**Response to Submissions
Mosman High School Upgrade
SSD 10465**

This document is provided by Woods Bagot, the architects for the project, as a response to the relevant submissions provided by DPIE, for the Mosman High School Upgrade State Significant Development Application.

2 Winter Solstice - 3pm Proposed

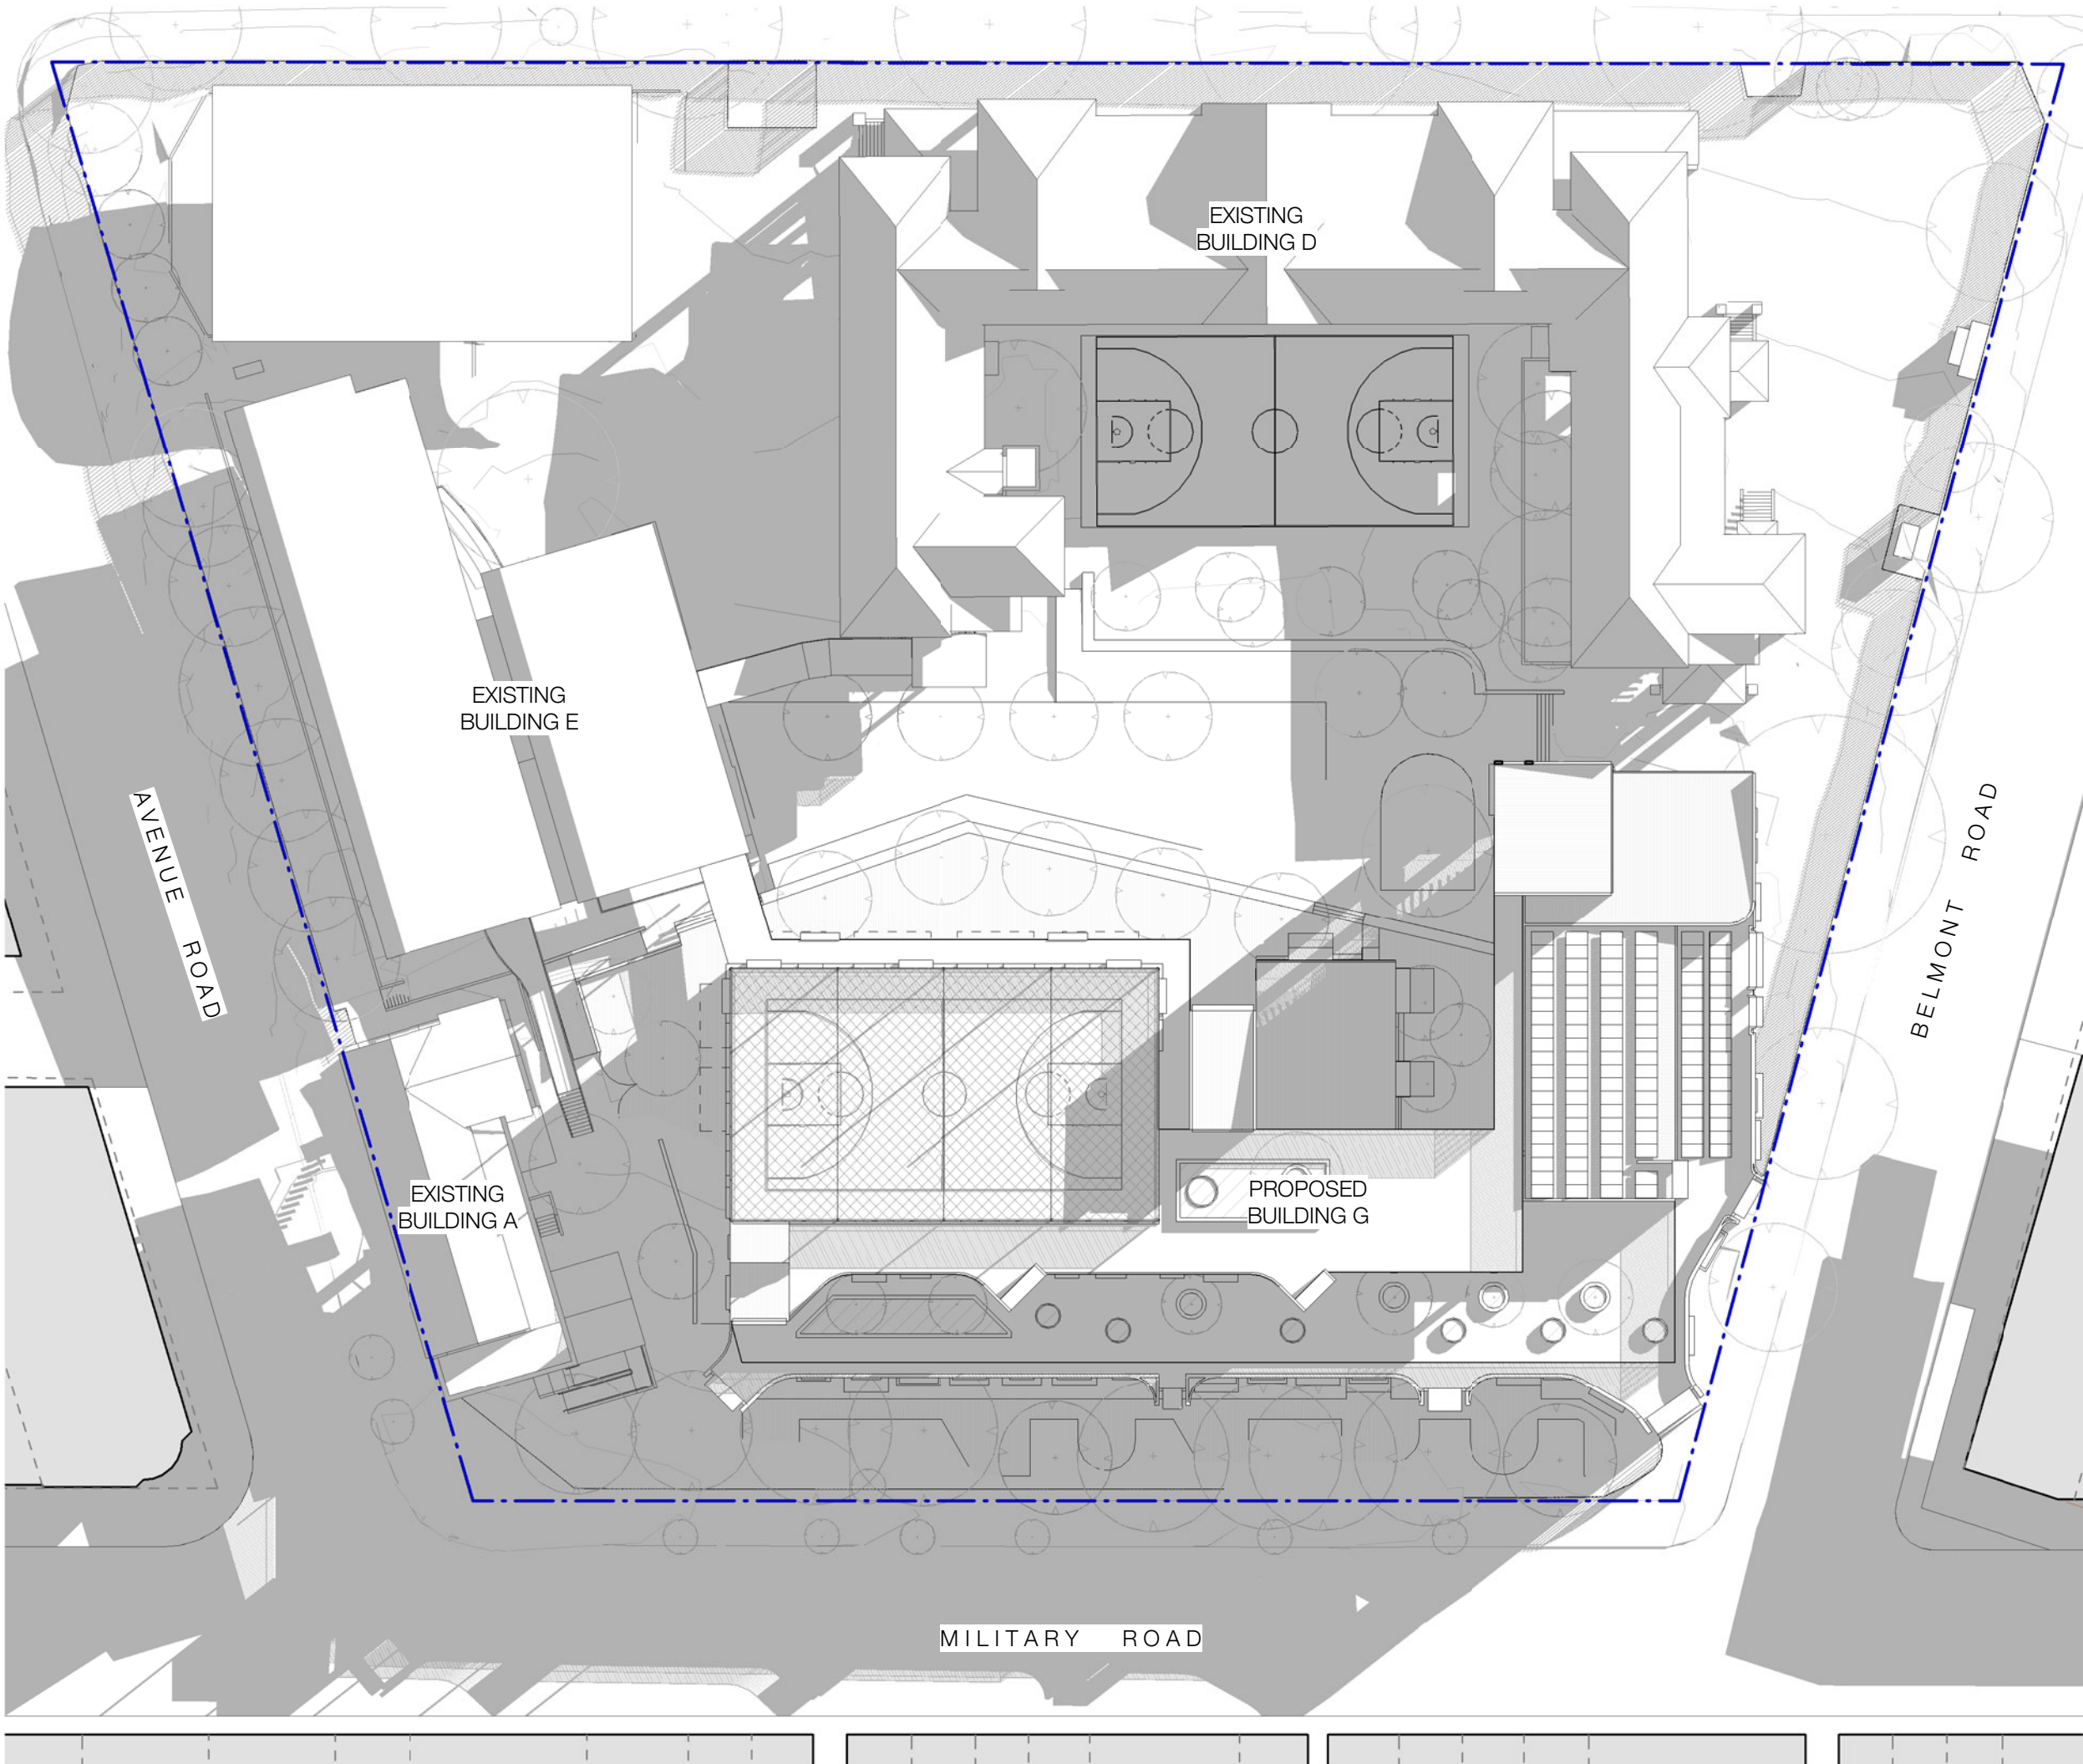
We note that plans submitted for public comment are only PRELIMINARY. This is unacceptable as they are technically incomplete and do not reflect the actual site complete shadow diagrams. Evidenced by the missing presentation of FULL SHADOW DIAGRAMS on impacted (Morning) Belmont Road, Keston Avenue & Avenue Road e.g. South West corner 6:00am(Summer) to 7:30am(Winter). Let's be honest – Easterly morning sun shine is critical to our neighbours amenity. (Afternoon) – Military Road retail shopping strip (Winter) 3:00 - 5:00pm. Let's keep the retail street sunny and a great place to shop.

Shadow diagrams are enlarged to capture the extend of Belmont Road, Avenue Road and Gladstone Avenue. There are no further shadowing impacts to Keston Avenue from Proposed building G from 9am to 3pm, winter and summer solstice.

Sheet number SSD-2206	Revision 2
Status PRELIMINARY

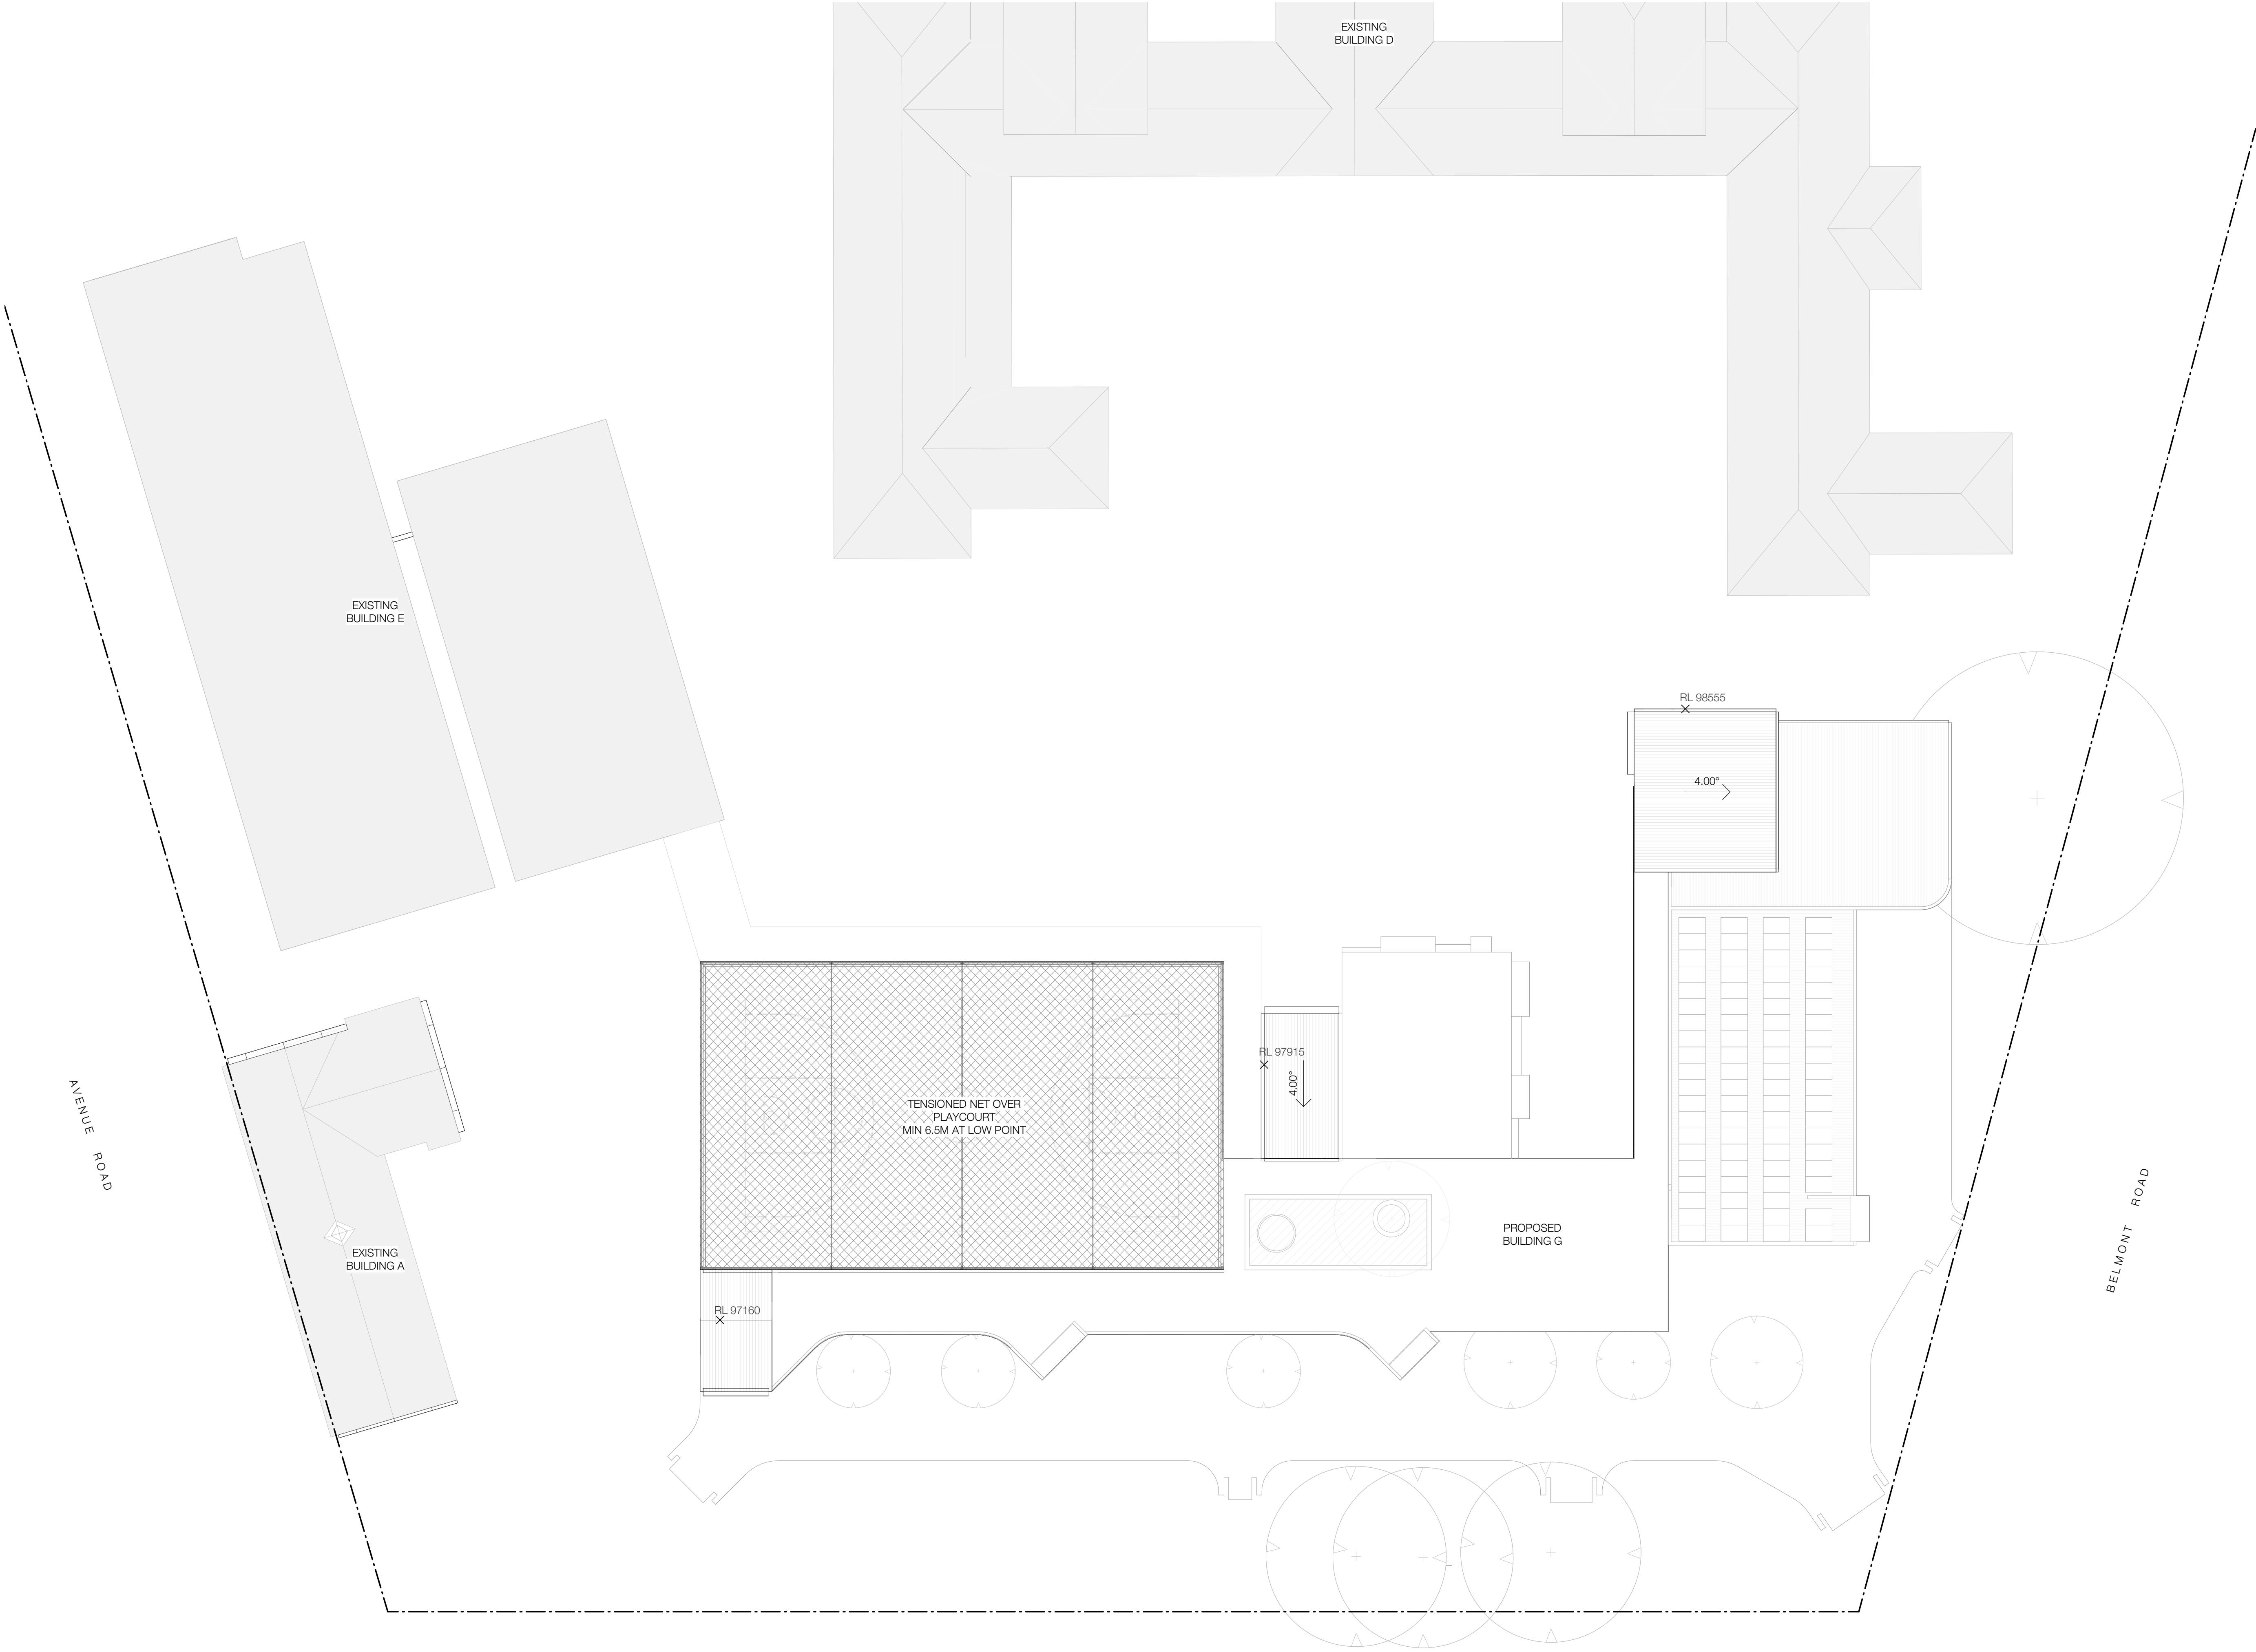
It appears that the level 4 roof court and stair core 3 will obstruct sightlines from the footpath on the east side of Military Road, refer to Sections A and B SSD-3201 Revision 2. In addition to the this, the height of the netting is identified as a minimum, which leaves open the possibility that the net height may be increased. This represents a departure from one of the commended elements of the architectural design strategy: that the stepped massing provided unobstructed sightlines from the footpath on the east side of Military Road, refer to advice letter dated 21.12.20. It is recommended that the design be reconfigured to achieve the unobstructed sightlines as detailed above.

The annotation of the netting has been updated to “Max. 8.5m Height” on both drawing numbers SSD-2206 and 3201.
